March 15, 2021

Re: Transportation Impact Study
Patriot Village – Security-Widefield, Colorado

PATRIOT VILLAGE
Transportation Impact Study

PUD DEVELOPMENT /
PRELIMINARY PLAN
ALTURAS DRIVE &
CABLE LANE

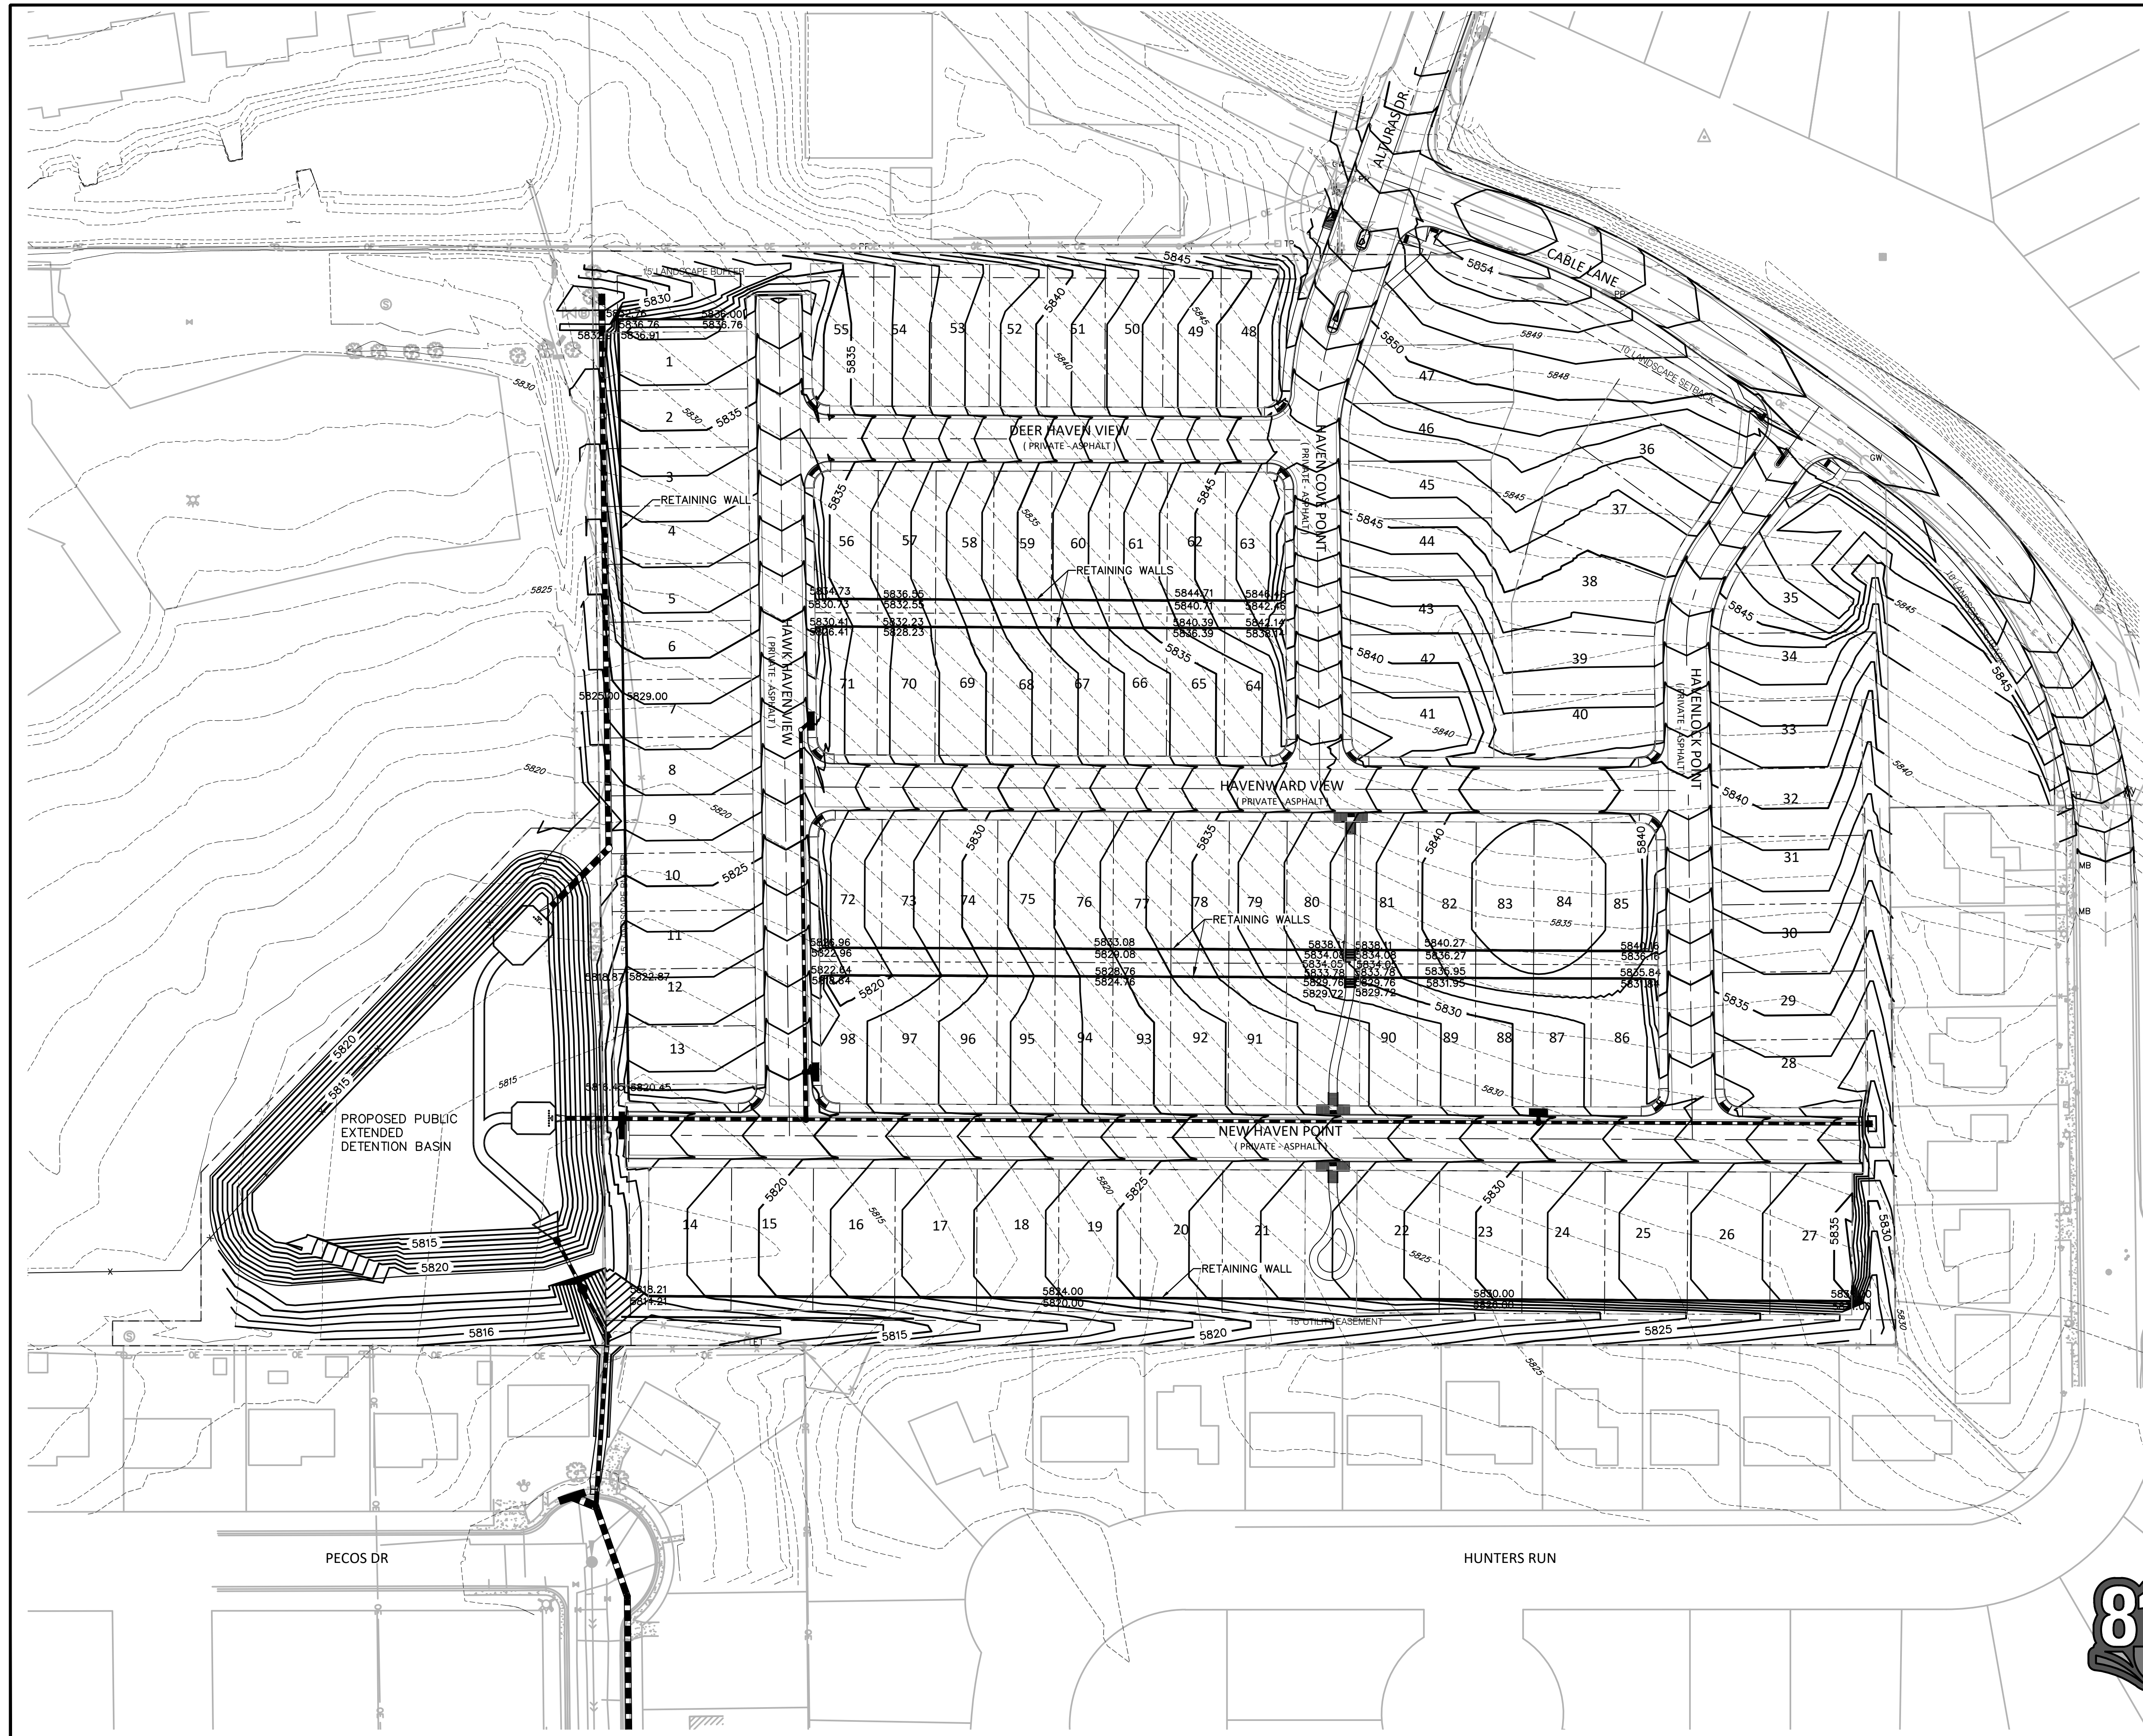
The PUD plan indicates the name of the project as Haven Valley. Please revise so that the documents are consistent with each other.

revise the name of the subdivision accordingly.

Done
